ALTERATIONS AND ADDITIONS TO GREYSTANES PUBLIC SCHOOL
781 Merrylands Road, Greystanes
EIS REVIEW - SSD 8778

COMMENTS IN RESPONSE TO STATE SIGNIFICANT DEVELOPMENT APPLICATION SSD 8778 GREYSTANES PUBLIC SCHOOL, GREYSTANES

1 GLA SOUTH ELEVATION
1:200

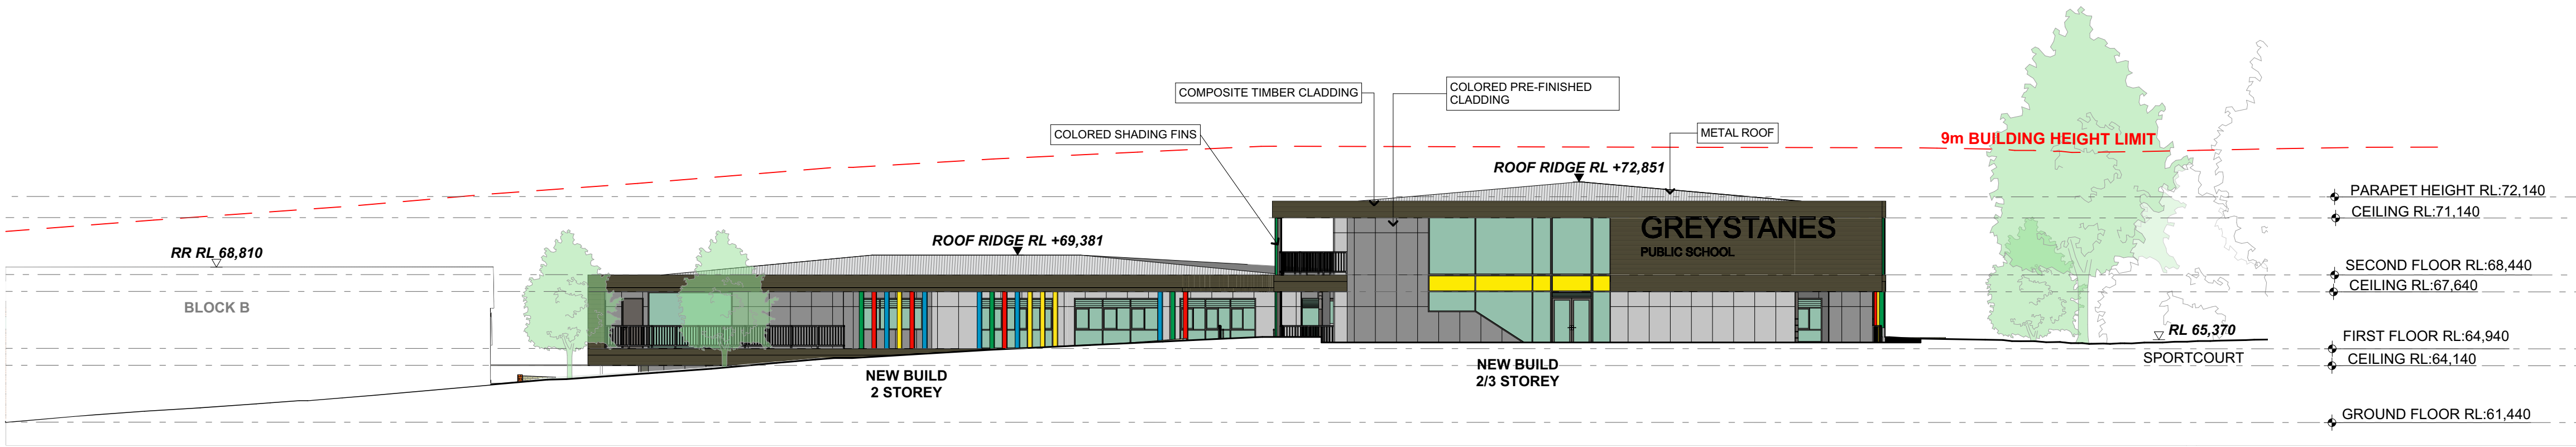
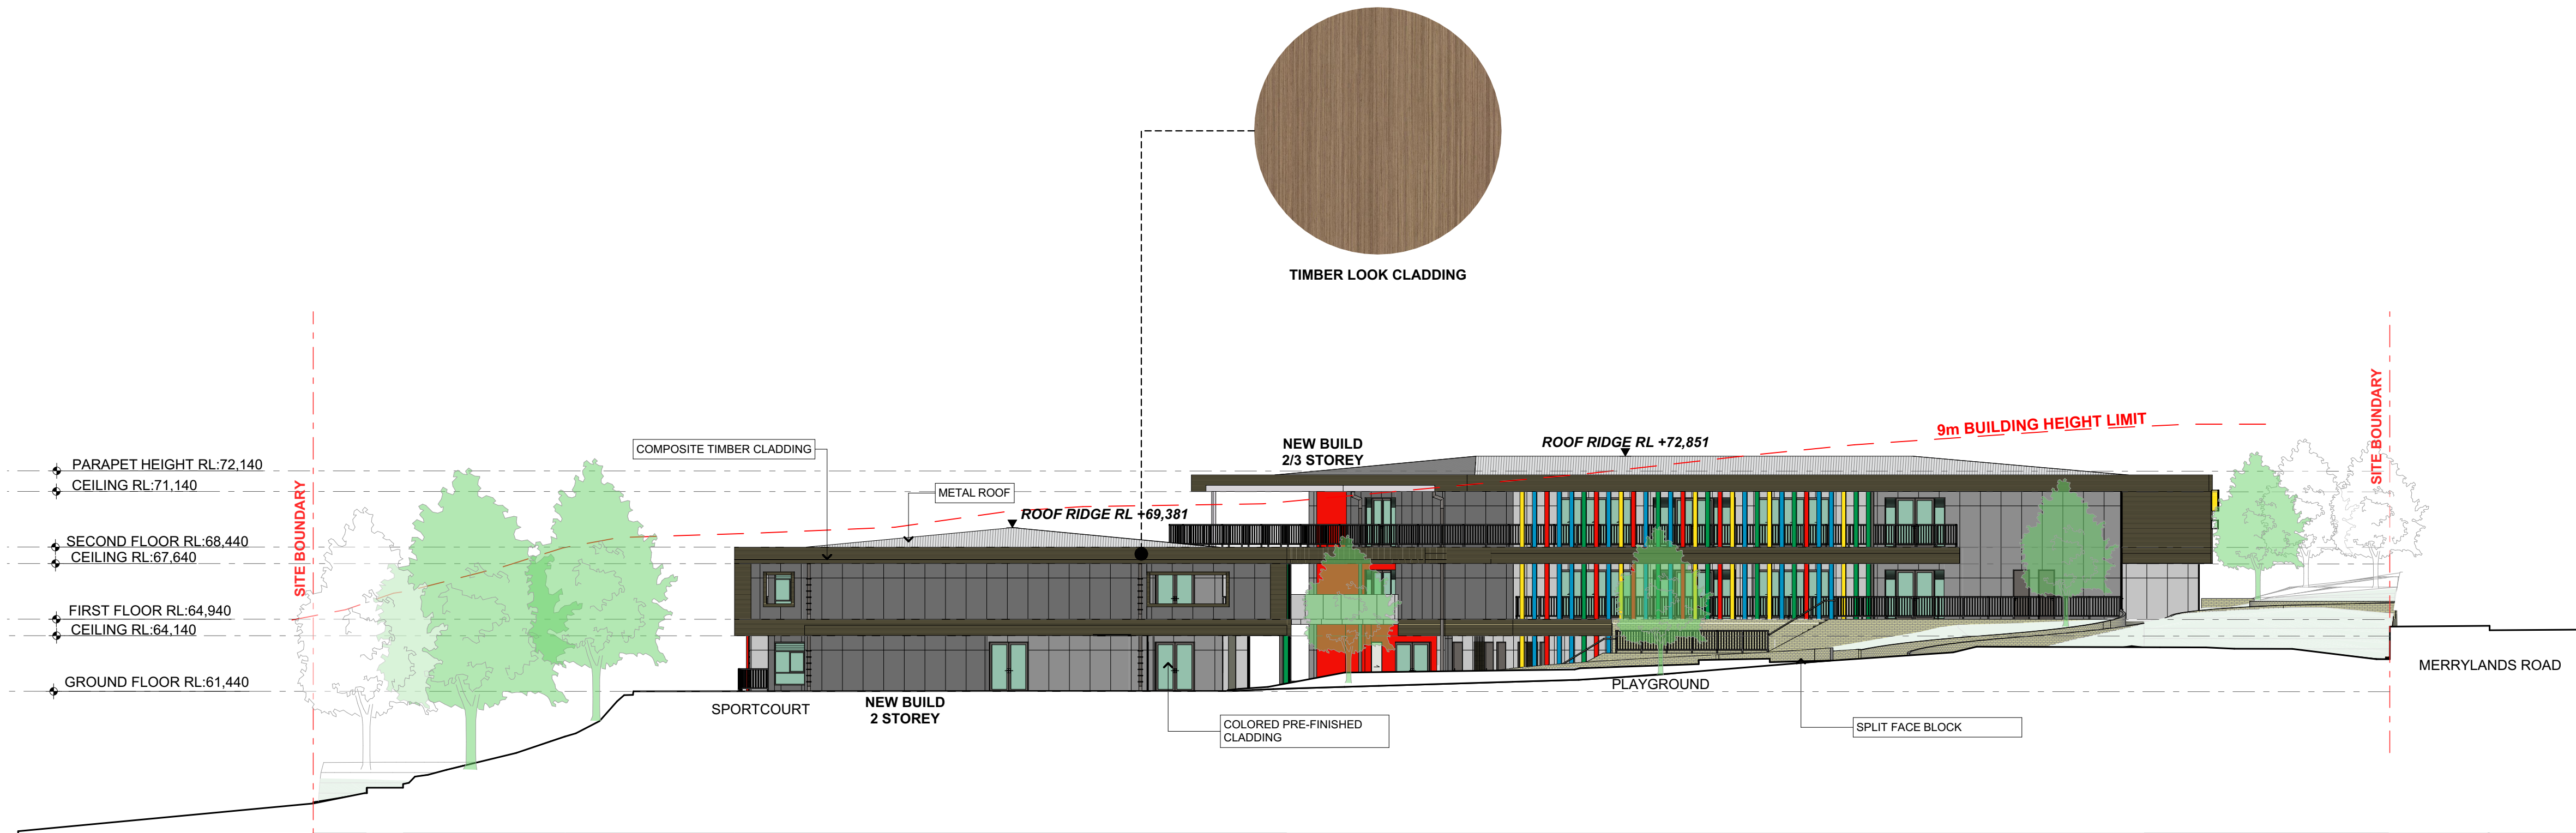
A range of architectural devices have been used across the facades of both the academic and administration buildings, including “pop-out” windows with green and blue trims, aluminum fins and areas of brick and fibre cement cladding. There are several variations in the composition of these materials on different elevations including the use of misaligned datums.

Whilst there has been some improvements to the elevations and general appearance proposed, concerns remain regarding the cohesion and appropriateness of the building presentation. Overall the aesthetic composition of the proposal would benefit from a simpler, clearer design approach that also

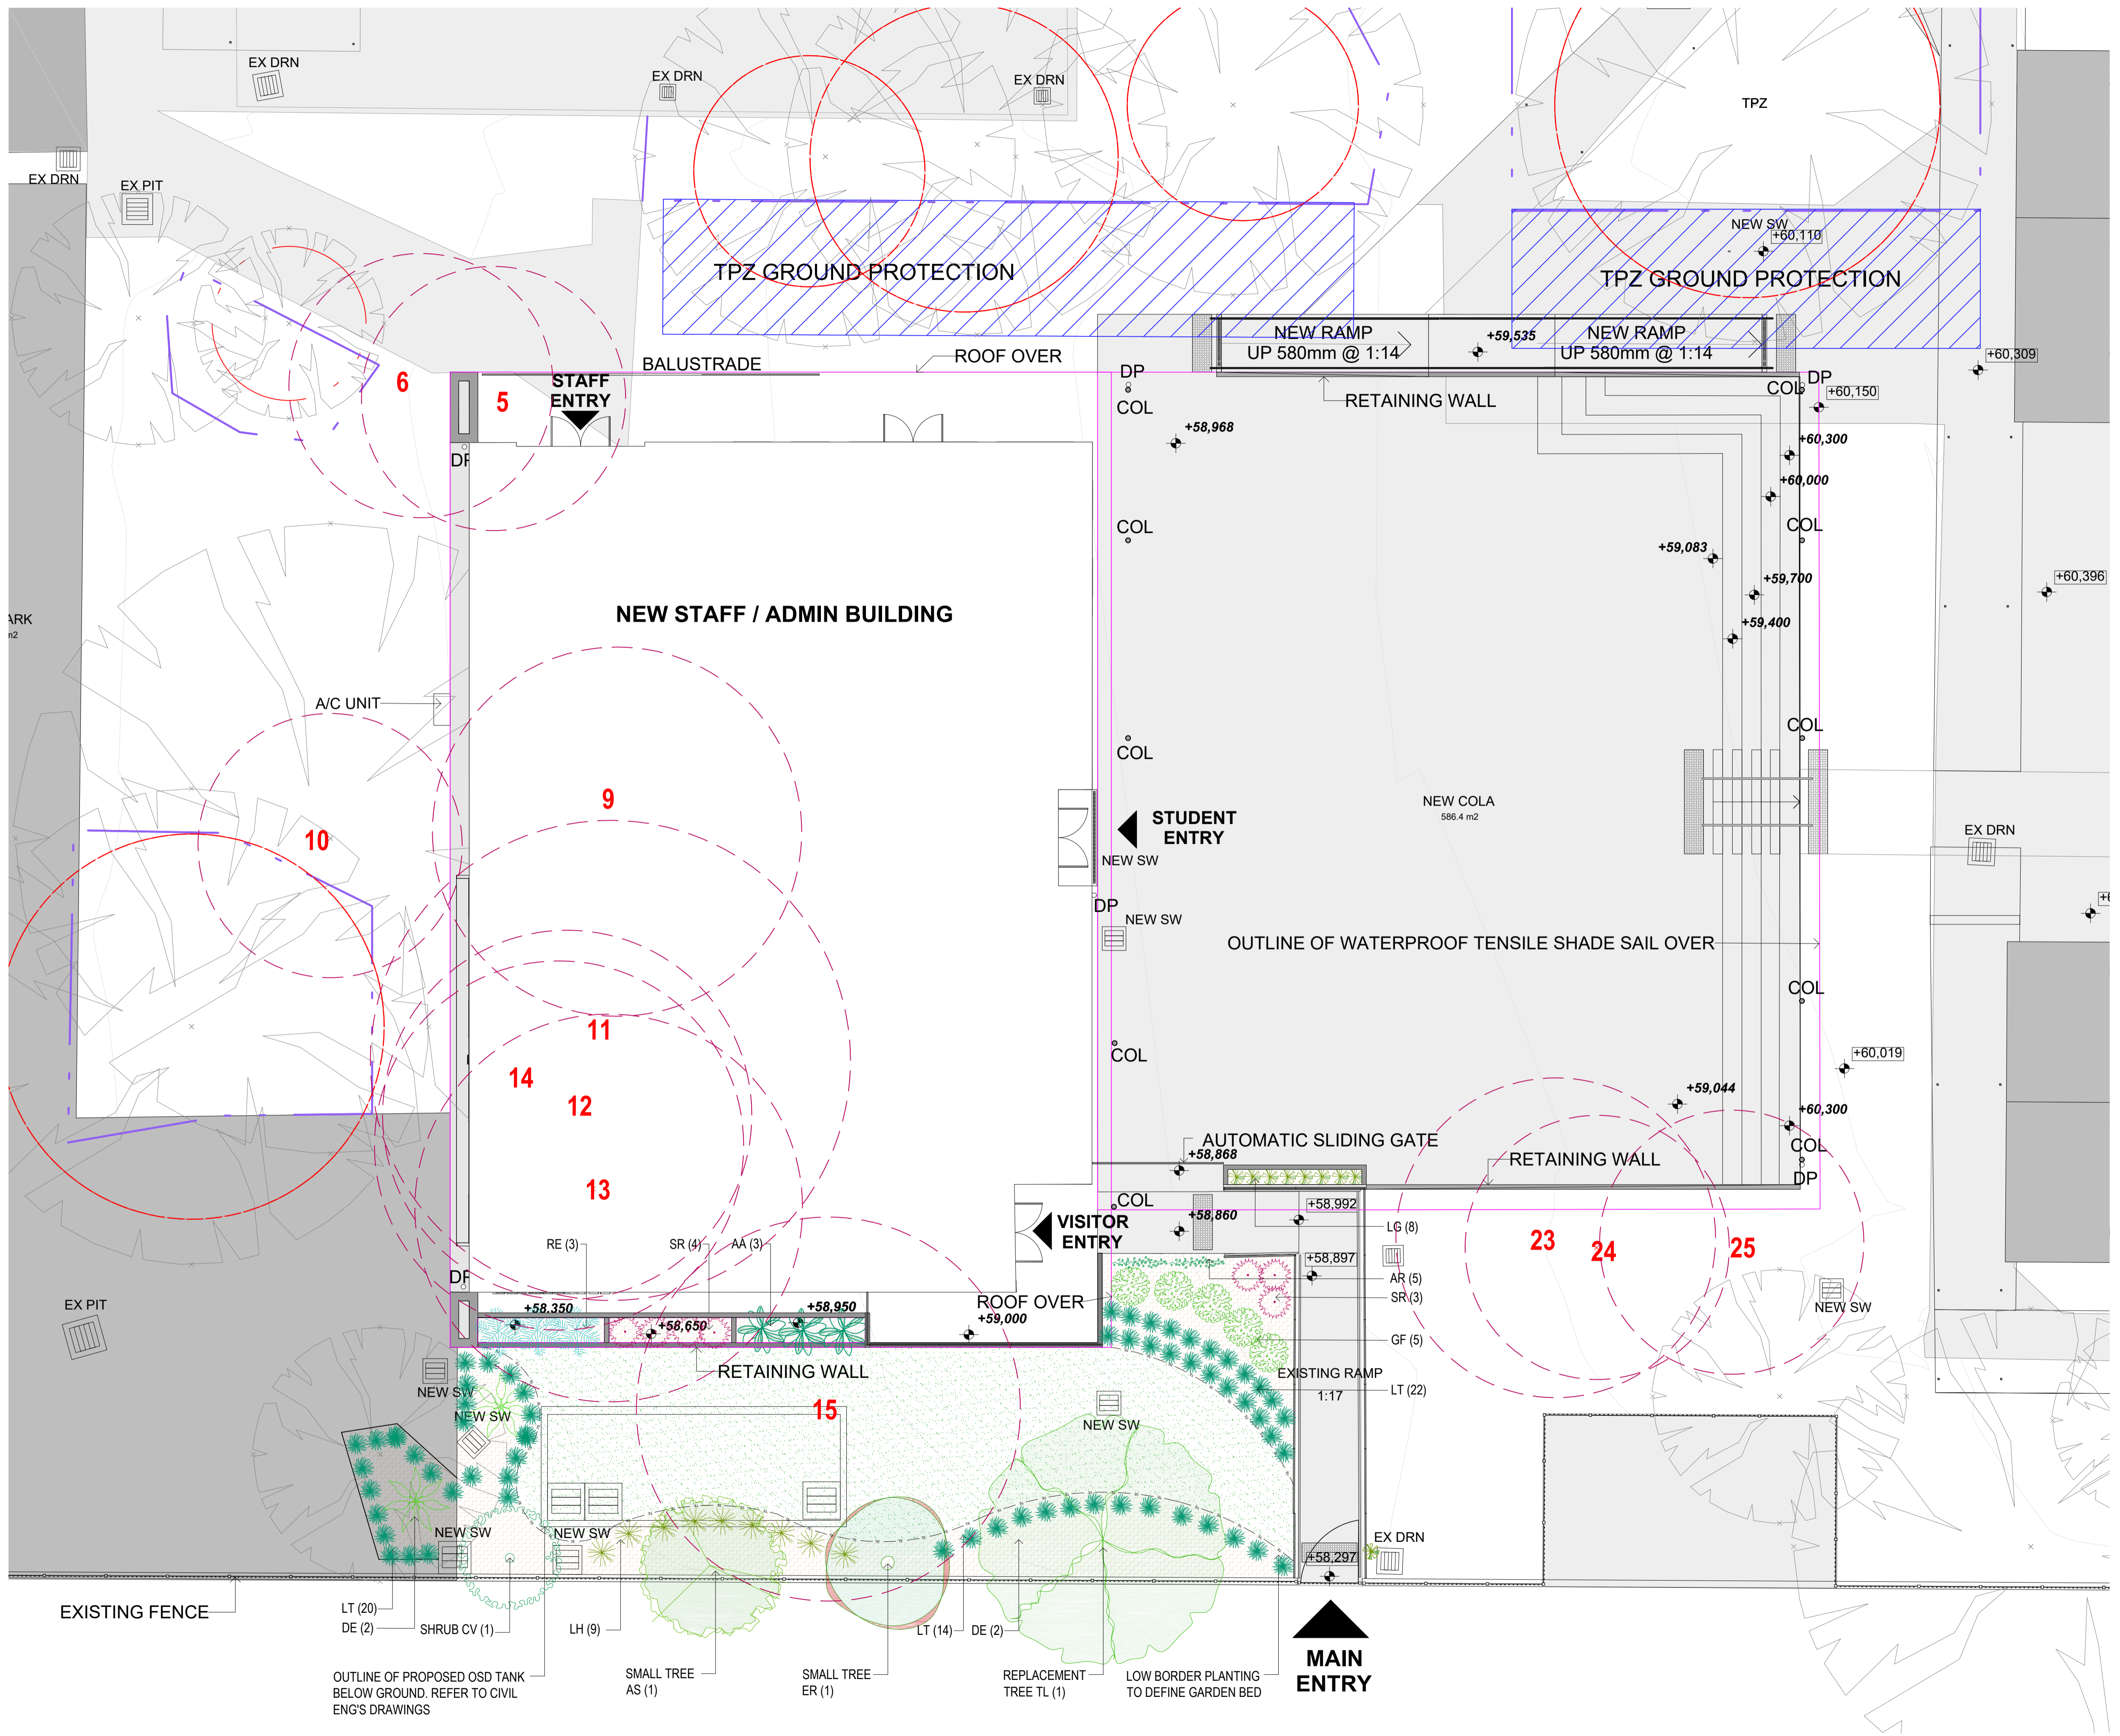
Landscape plans generally should be updated to include and respond to the current architectural proposal.

The landscape plan has not been updated in accordance with the latest architectural plans. A revised and integrated landscape plan should be provided that clearly articulates a detailed landscape proposal for these spaces. Wayfinding and connectivity across the site should also be considered and integrated in the landscape approach.
